DECISION DELEGATED TO HEAD OF PLANNING

Application No:	H13-0728-26	Applicant:	Mr H Myers
Proposal:	Proposed extension, garage conversion to provide living accommodation, demolition of existing outbuilding, erection of new outbuilding, removal of one site access & new boundary treatments including fencing - Approved under H13-0334-25. Modification of Condition 2 to allow amendments to previously approved plans		
Location:	Glebe House Church Street Moulton		
Terminal Date:	16th October 2026

CASE OFFICER ASSESSMENT

Drawing Title:
Elevations as Proposed

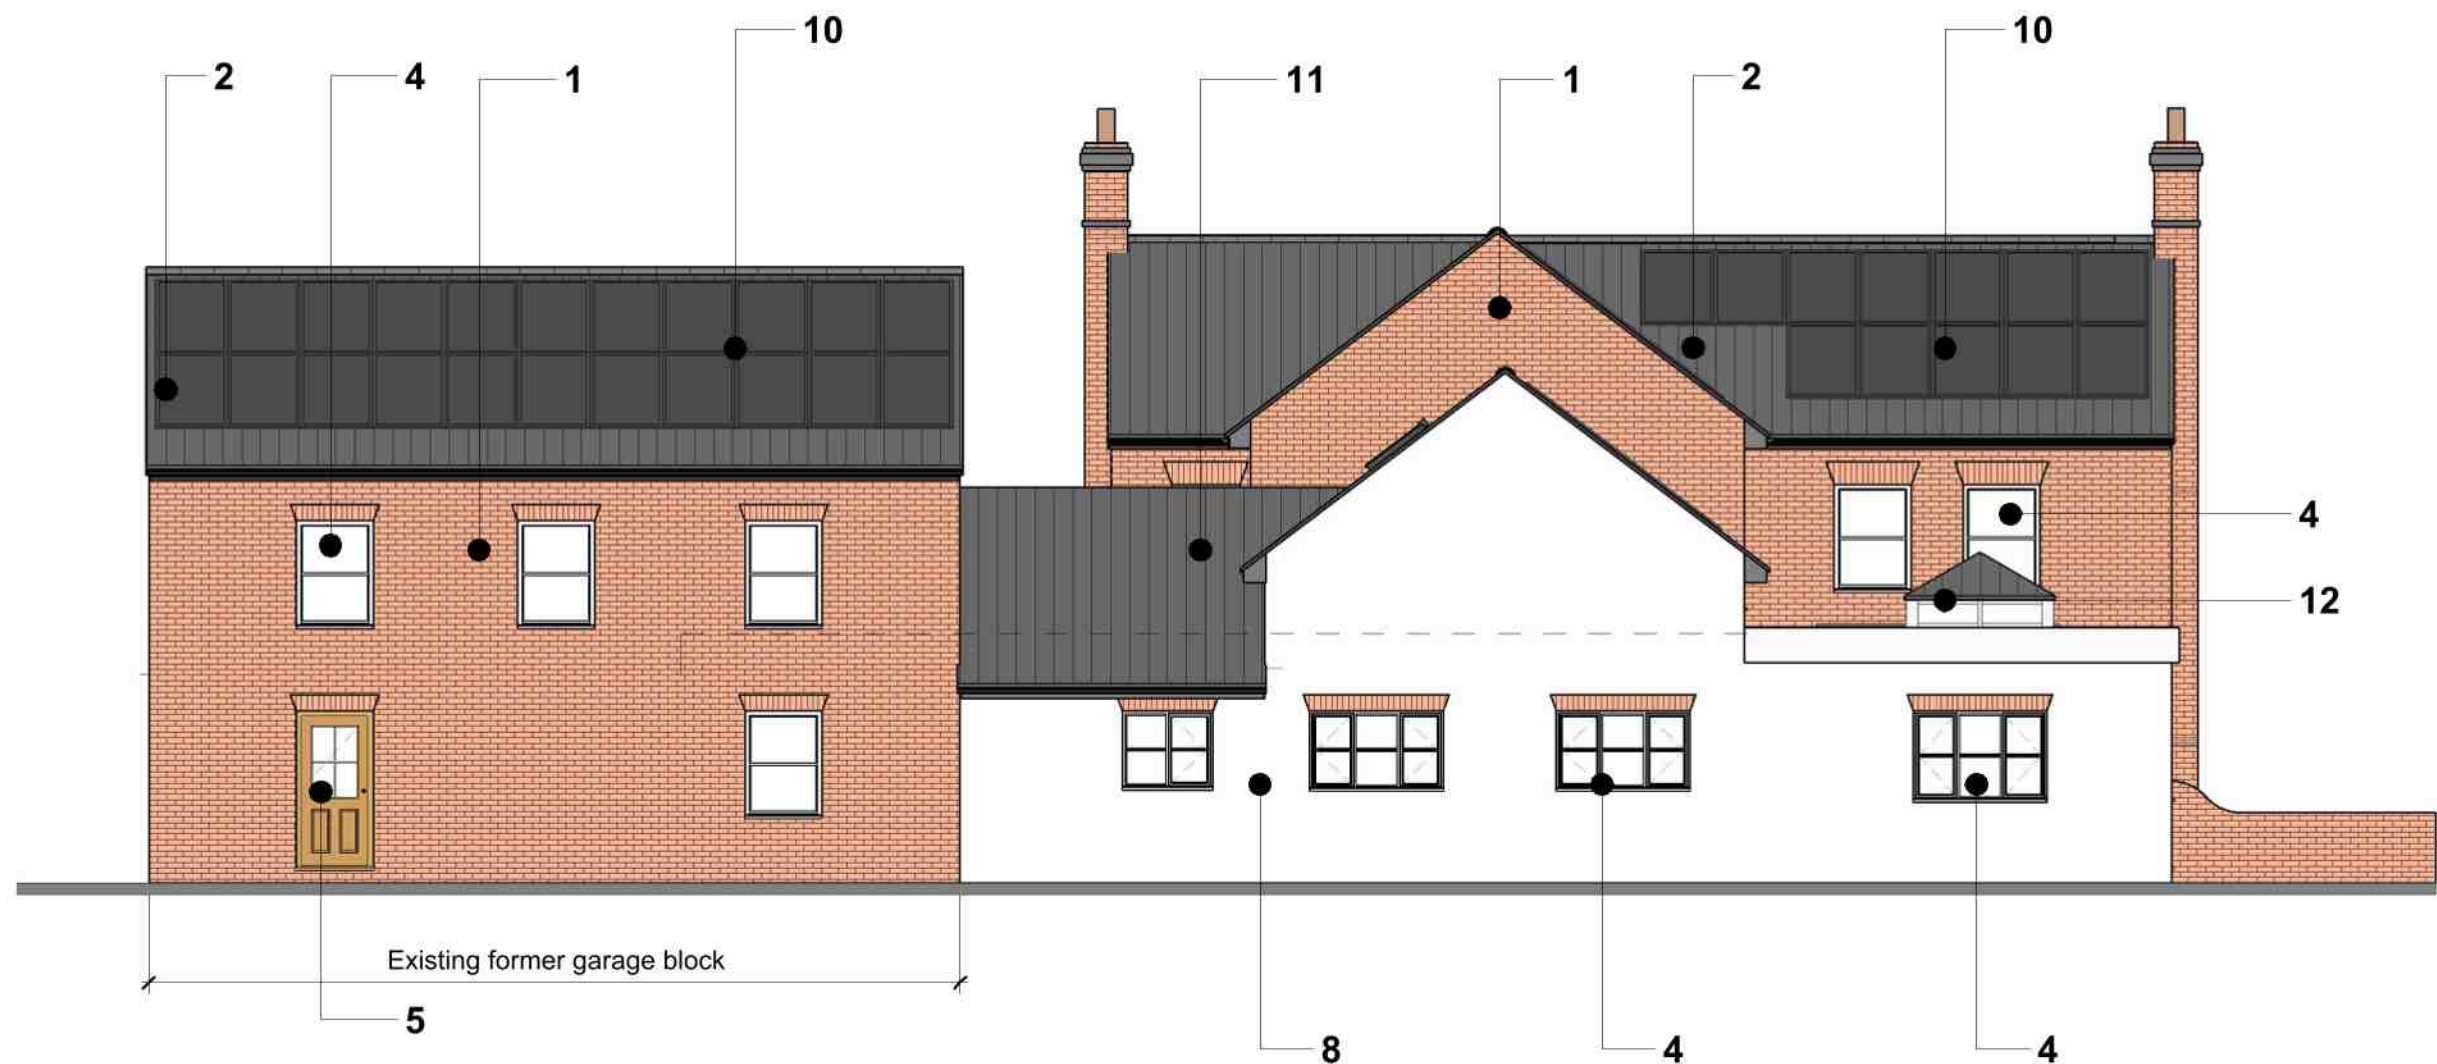
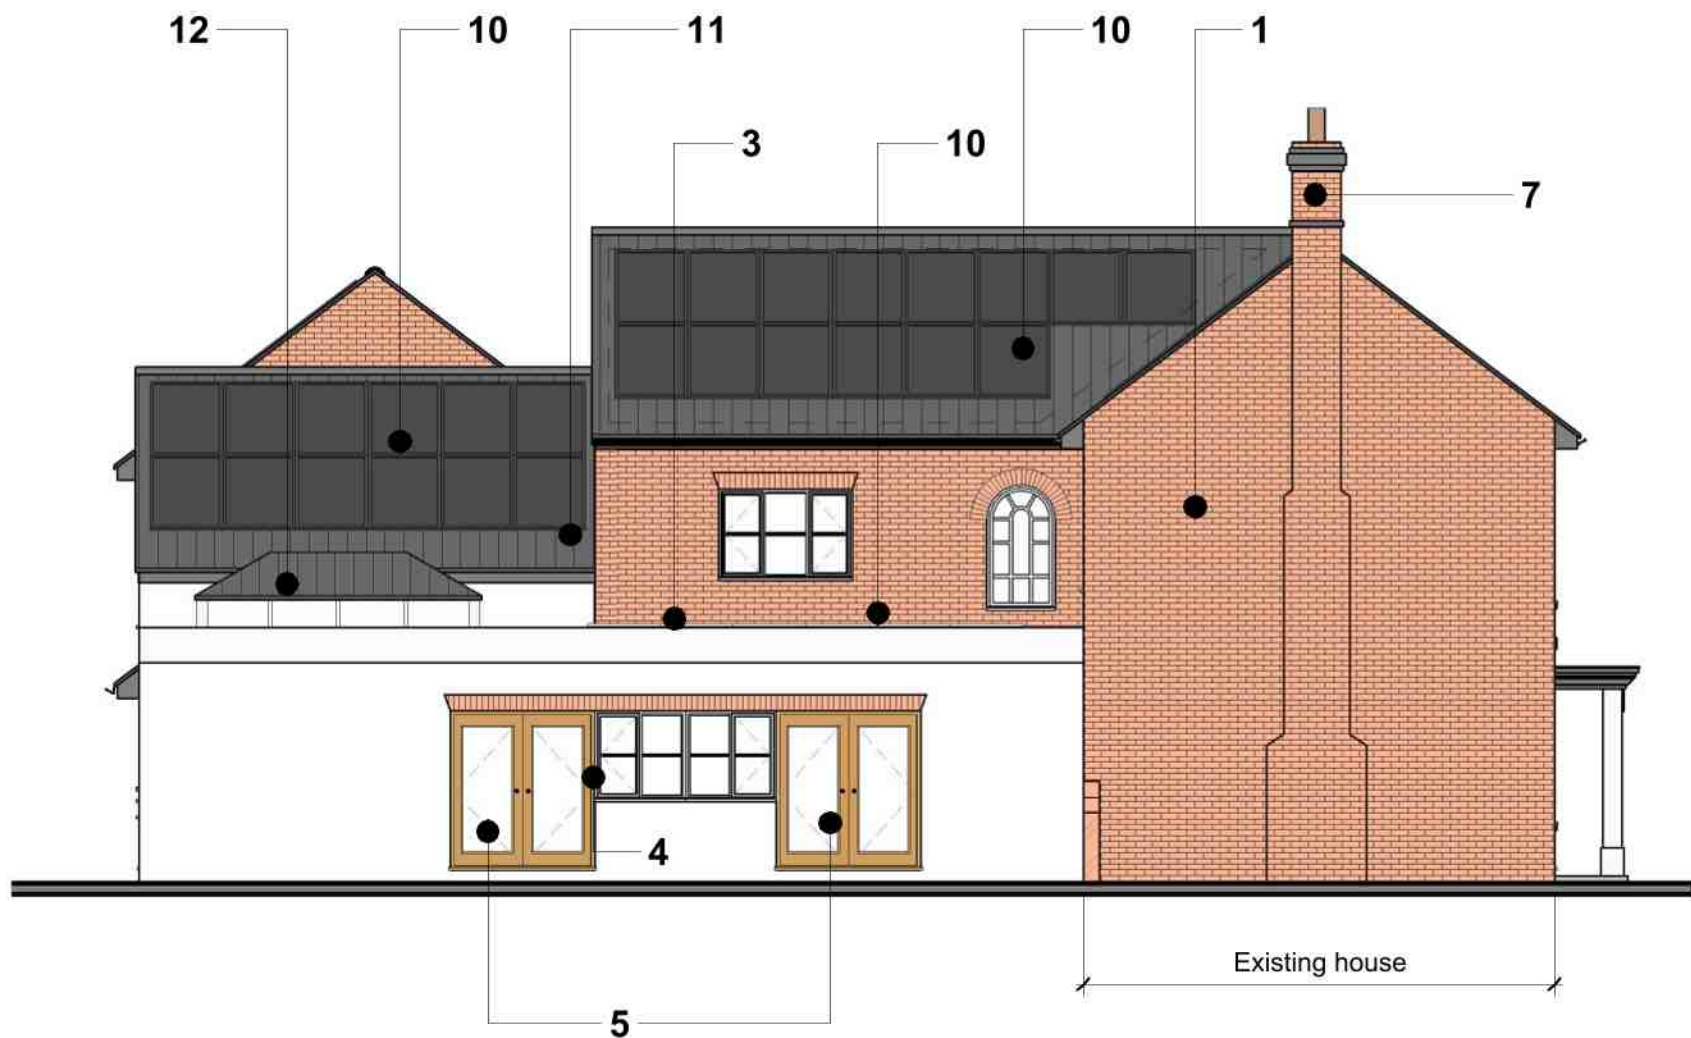
The amended elevation plans do not address our concerns regarding the refacing of the garage building. Additionally, why has the decision been made to have two single panel windows on the first floor of the garage? I fear this will look odd when looked at with the 1:1 sash windows. I understand that the windows have been approved under H13-0334-25 and that condition 3 requests details of these windows. We would expect to see elevation and cross section details including measurements of the meeting bar and frame

The proposed roof lantern is an unusual feature. The feature is off-centre in the flat roof, and does not fully reflect the proportions of the roof it sits in. The inclusion of tiled covering increases the visual mass of the feature and creates a greater degree of friction with the flat roof it sits within. It does not integrate itself well into the dwelling or the wider extensions. That being said, the works would be almost entirely hidden from the public realm. Moreover, views from the plot itself would be limited, due to the height of the flat roof element in which it would sit. Therefore, the tangible impacts are reduced.

The proposed reconstruction of the garage's east elevation is unusual. It has been stated brickwork to match the existing will be used. Finding an exact brick match, including in terms of weathering, is likely to prove difficult, meaning that there would be a degree of contrast between this elevation and the wider dwelling/ garage. That being said, this difference would likely not be so significant as to be harmful taken in isolation of wider elements. The comments of the Conservation Officer are noted; however, their concerns appear to stem primarily from the incorporation of the garage block into the wider dwelling. Given that this has already been approved, and that their comments do not relate to brickwork per se, it is considered that this would not be a valid ground to resist the application.

The increase in height of the rear element would increase the perceived mass and bulk of the property. That being said, the alteration would still be largely obscured from the public realm via the existing property. The roof pitch mirrors the host, increasing the integration of this element. On balance, whilst the alteration is not necessarily beneficial to the appearance of the extension, is not overtly negative either.

The comments made by the Conservation Officer relating to the HIA have been addressed in full via an amended scheme.
